CITY OF ALBUQUERQUE

**Planning Department
Transportation Development Services Section**

Re: Certification Submittal for a Permanent Building Certificate of Occupancy
(C.O.) for CVS Pharmacy [J23/ D015]
1510 Tramway NE
Engineer's Stamp Dated 06/24/11

Re: Certification Submittal for a **120-day Temporary Building Certificate of Occupancy (C.O.)** for CVS Pharmacy [J23/ D015]
1510 Tramway NE
Engineer's Stamp Dated 06/24/11

AMENDED SITE DEVELOPMENT PLAN FOR SUBDIVISION AND BUILDING PERMIT

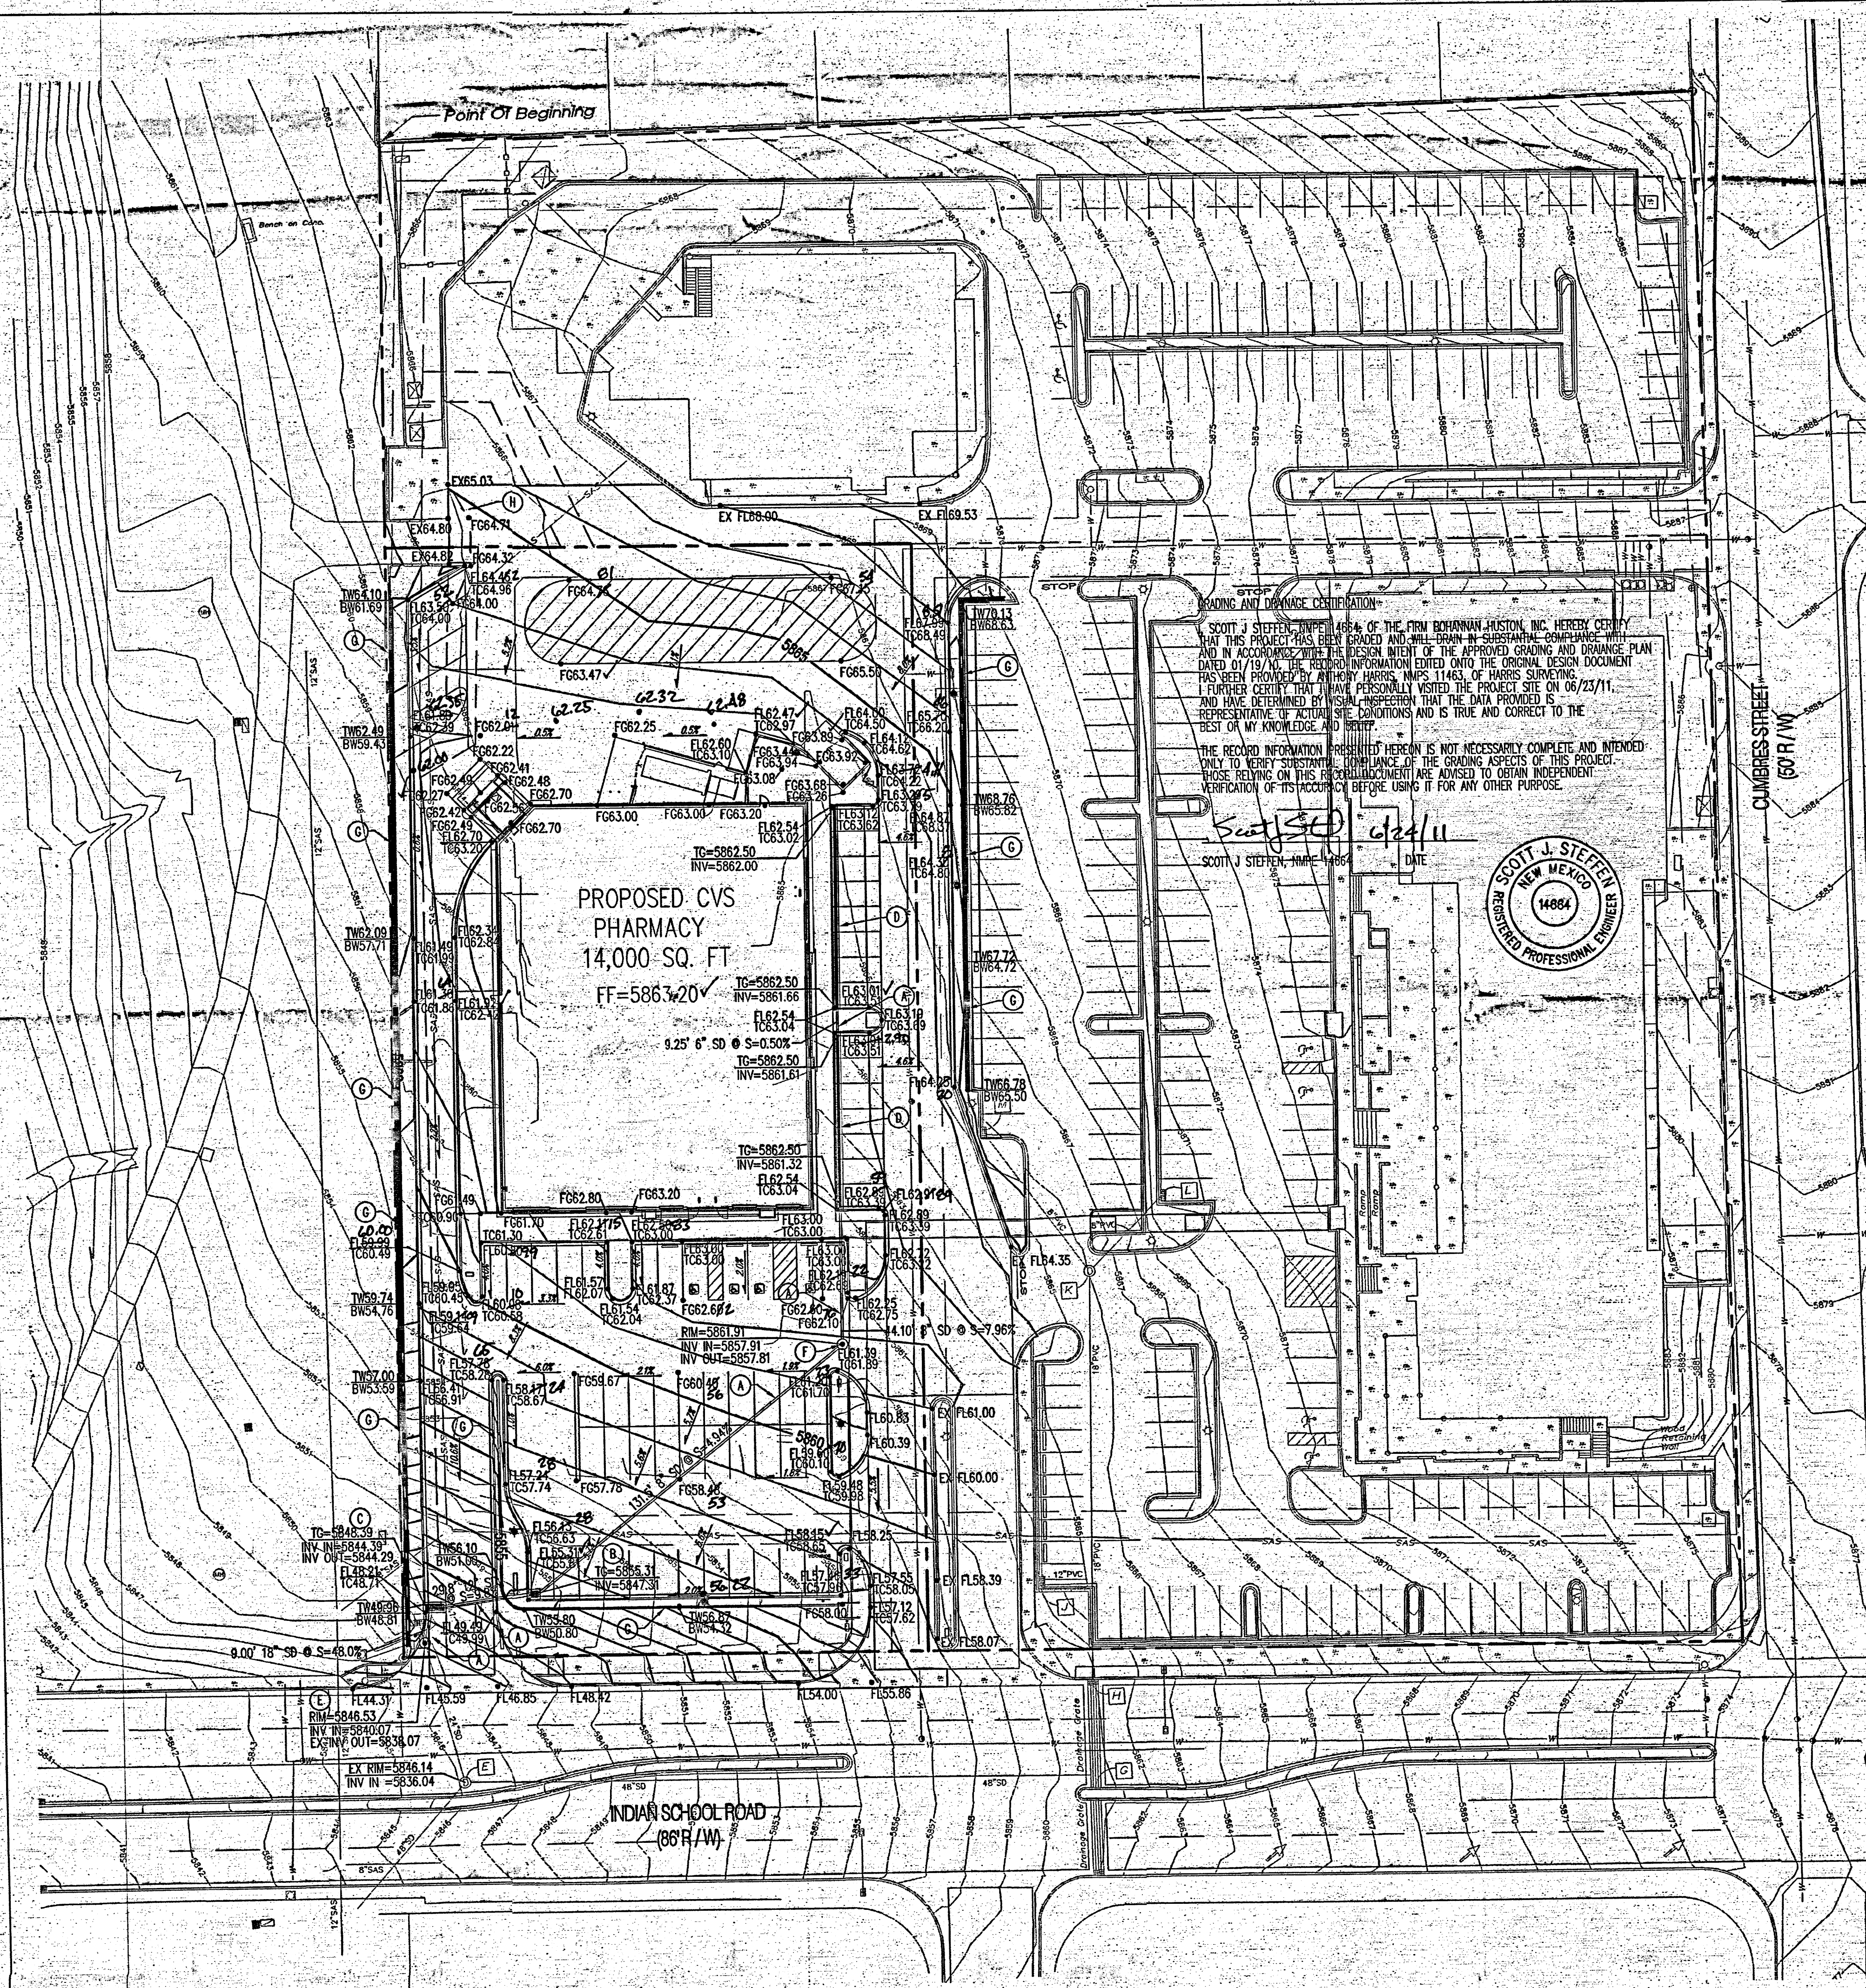
The following items will need to be addressed prior to issuance of a Permanent Certificate of Occupancy (As a condition for Permanent CO approval): Show/redline new location of light pole on Site Plan and it appears that the drive aisle has been decreased to less than 24 foot aisle width adjacent to fire lane (Not acceptable), please modify to provide a minimum of 24 feet of drive aisle. Once this issue has been addressed you'll need to re-submit the total package for Permanent C.O.
